3/17/26

I-5719B_U5800_Submittal S-008-4B Plans
MI-Engineering- Hydraulics Review

PROJECT REFERENCE NO. I-5719B / U-5800	SHEET NO. 04
ROADWAY DESIGN ENGINEER	HYDRAULICS ENGINEER

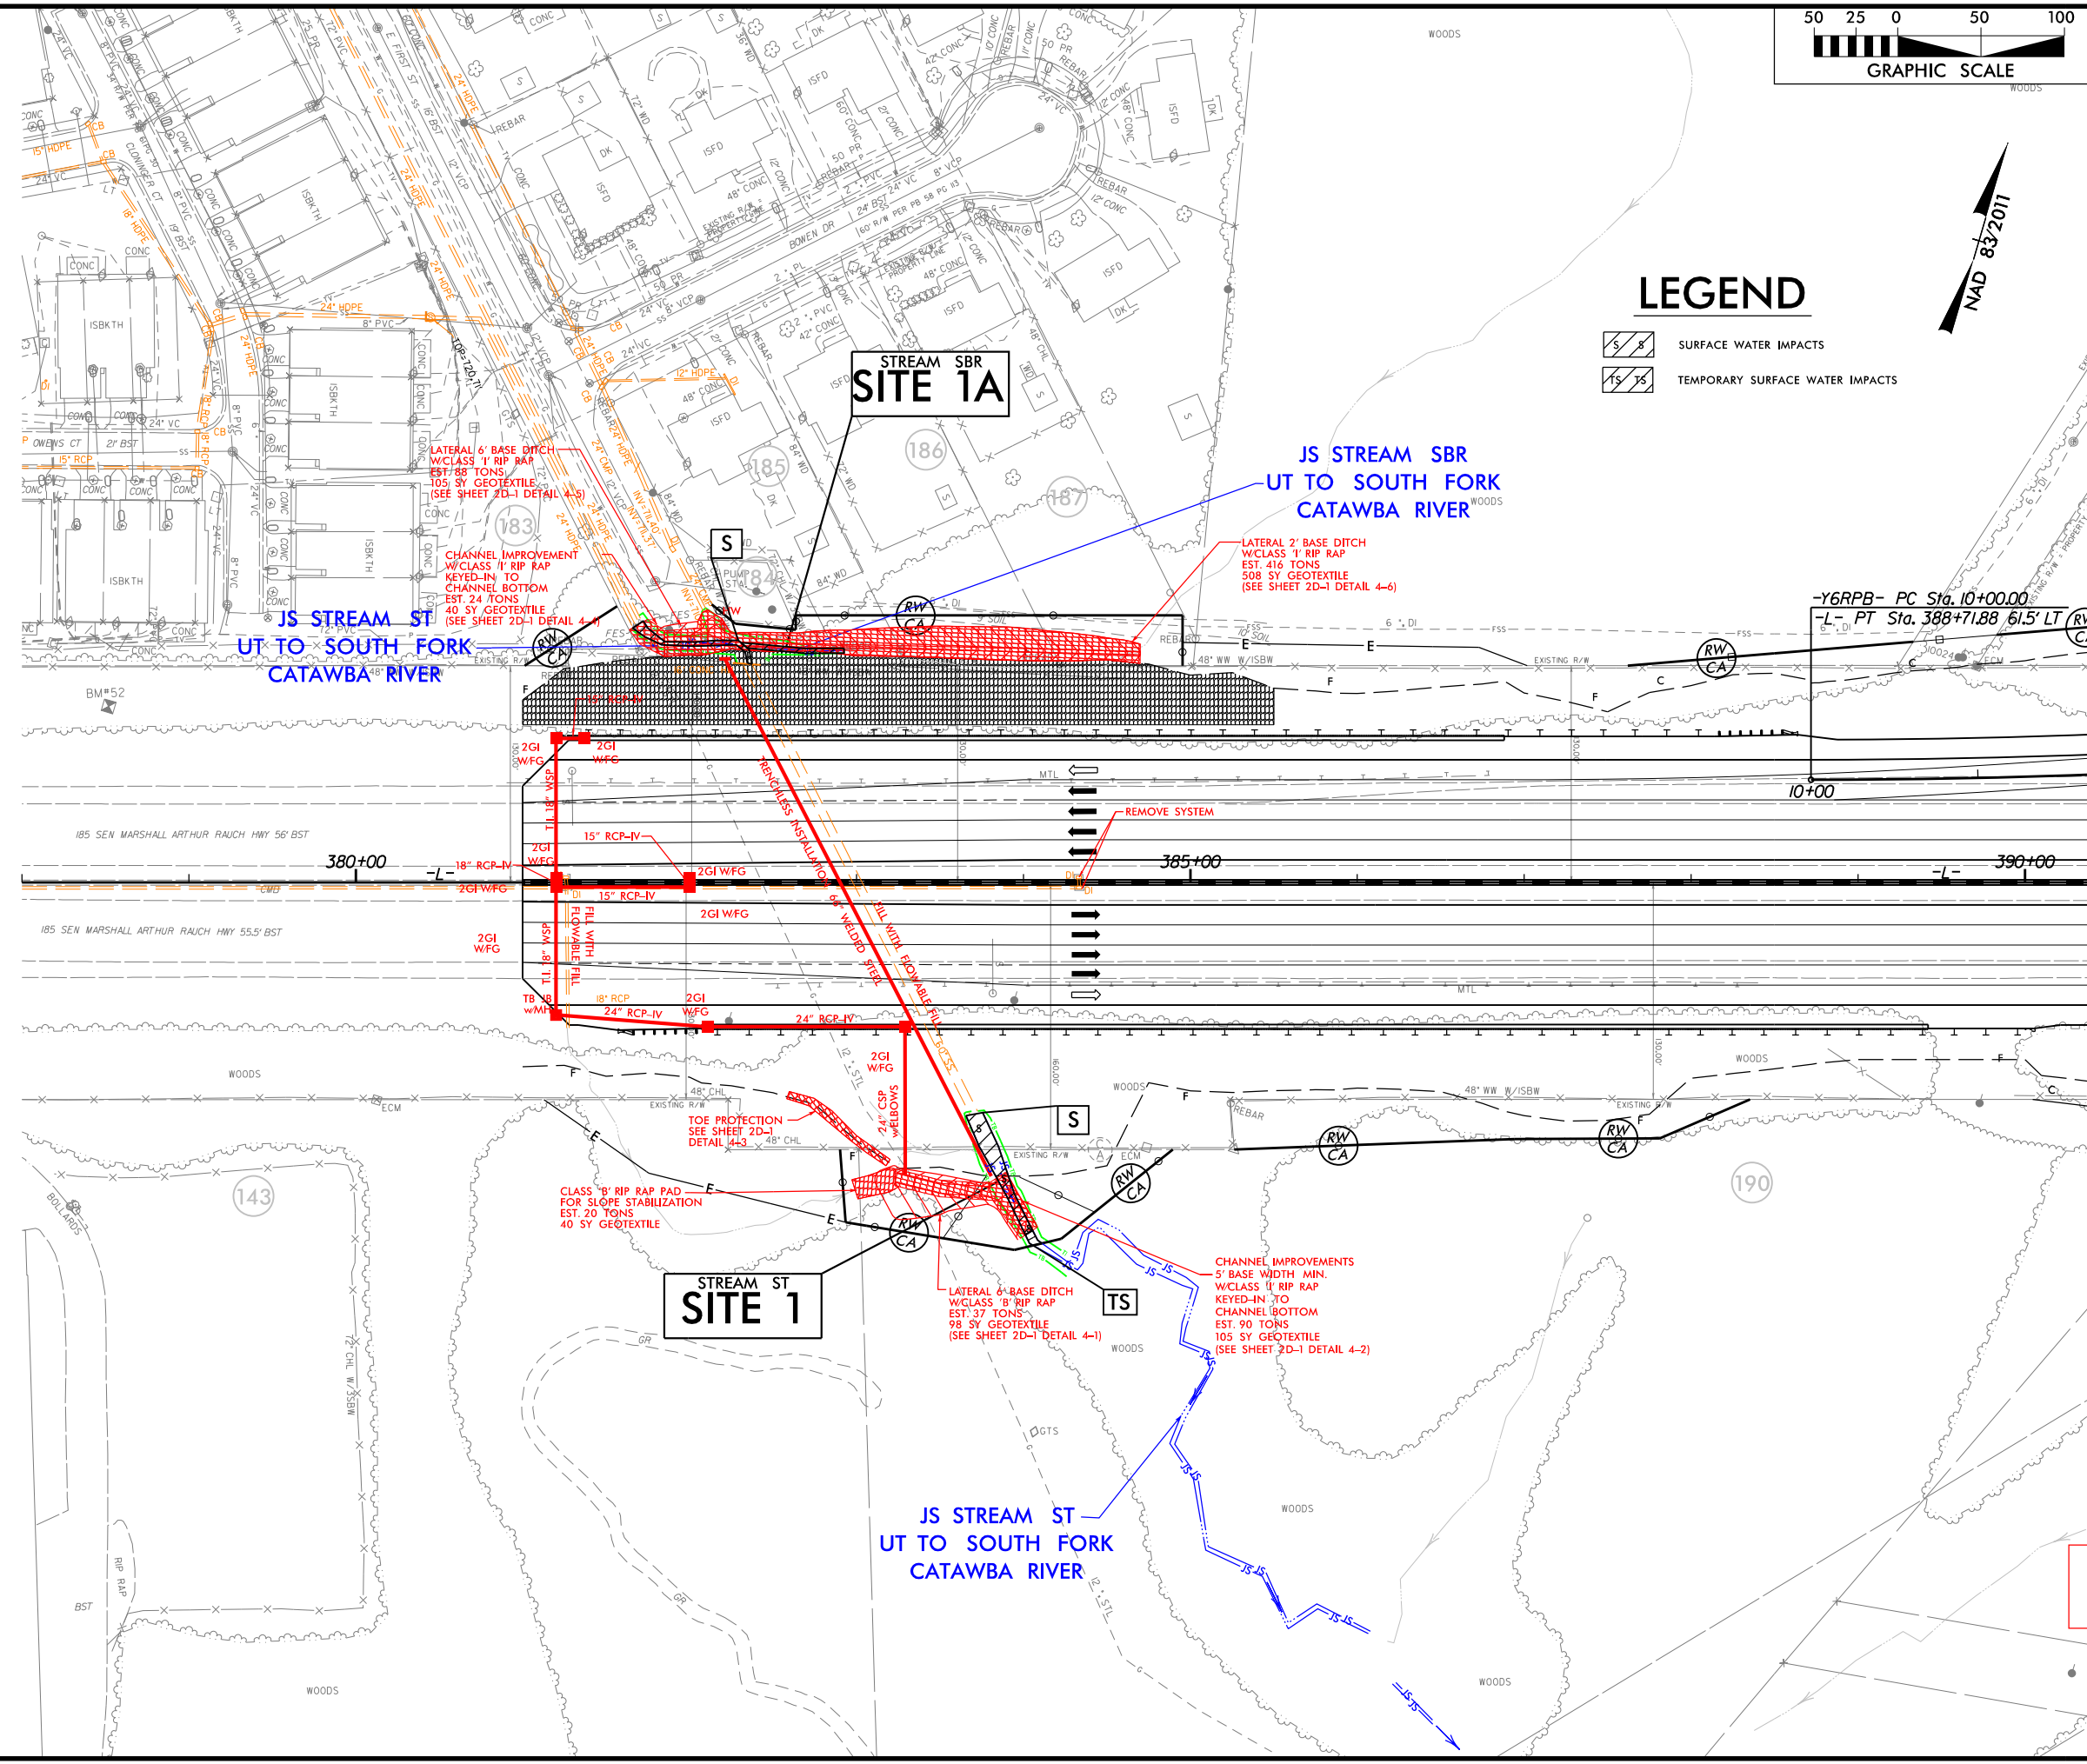
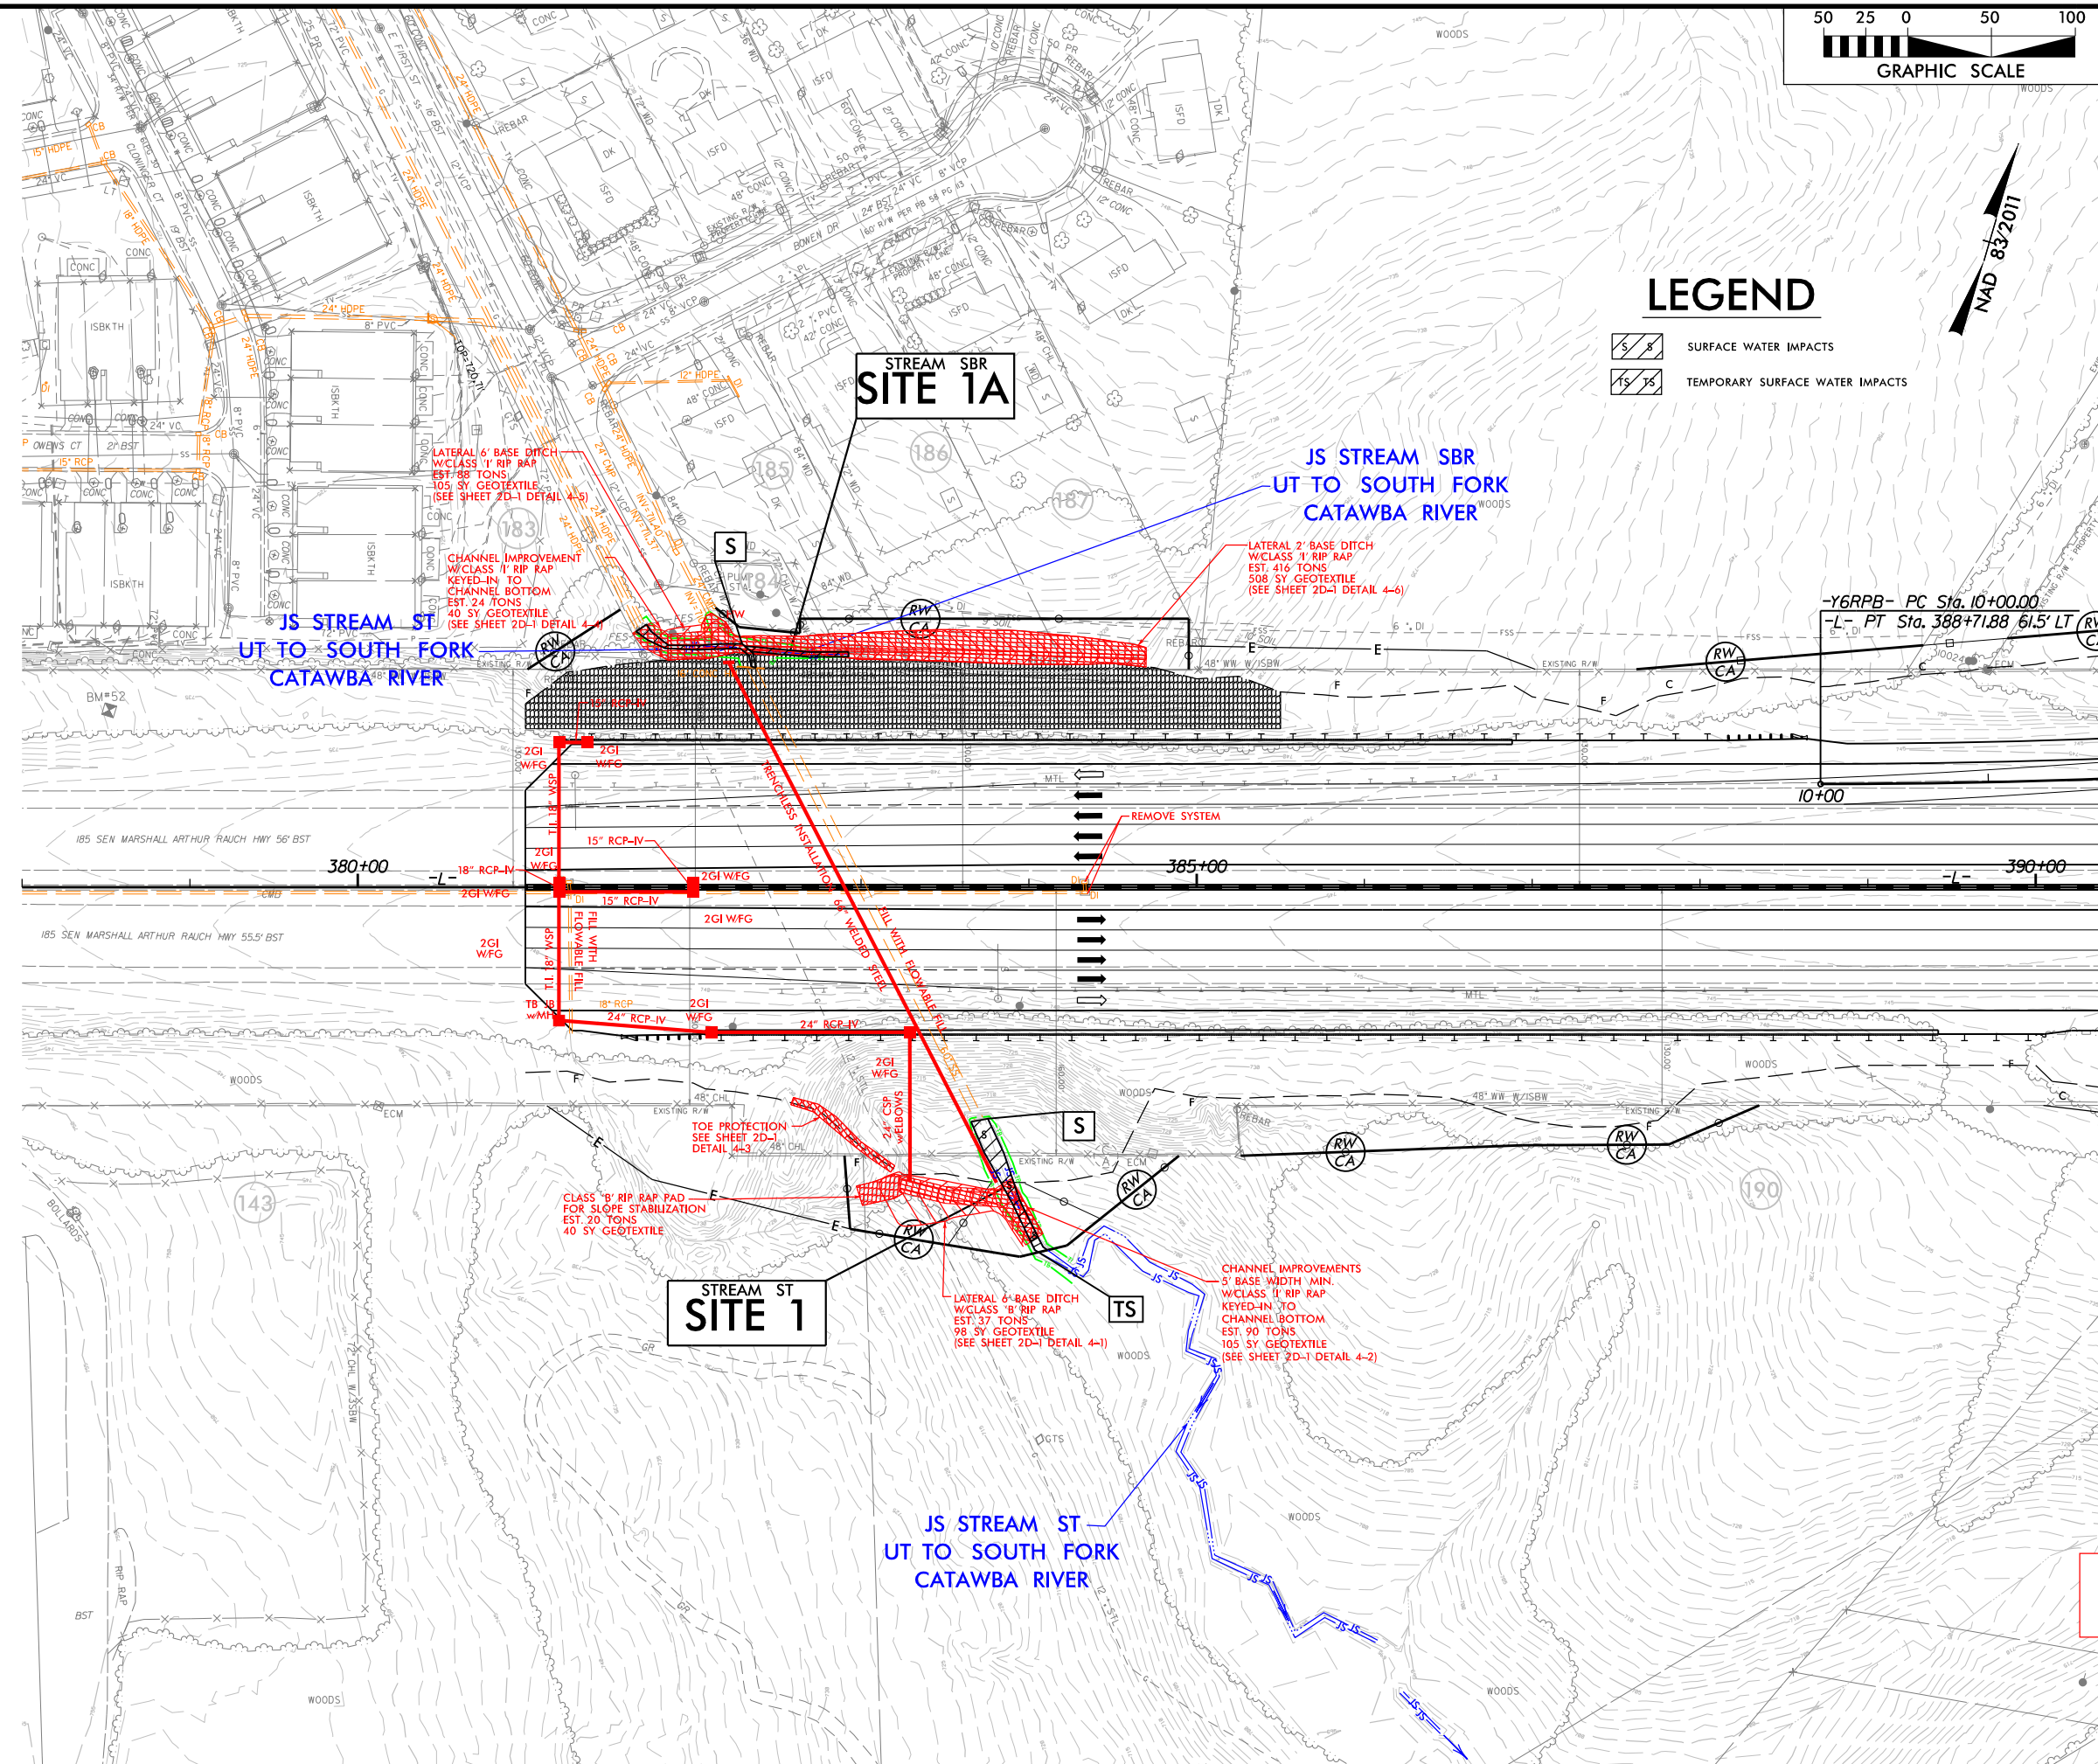
- Show channel realignment into entrance of 72” pipe at station 382+90 -L-.
 - [Channel geometry revised to reflect the comment.](#)
- Adjust proposed channel improvement at outlet of 72” pipe at station 382+90 -L- so it lines up with pipe outlet.

- Channel geometry revised to reflect the comment.
- Are sills proposed for this pipe?
 - Discussion for meeting.
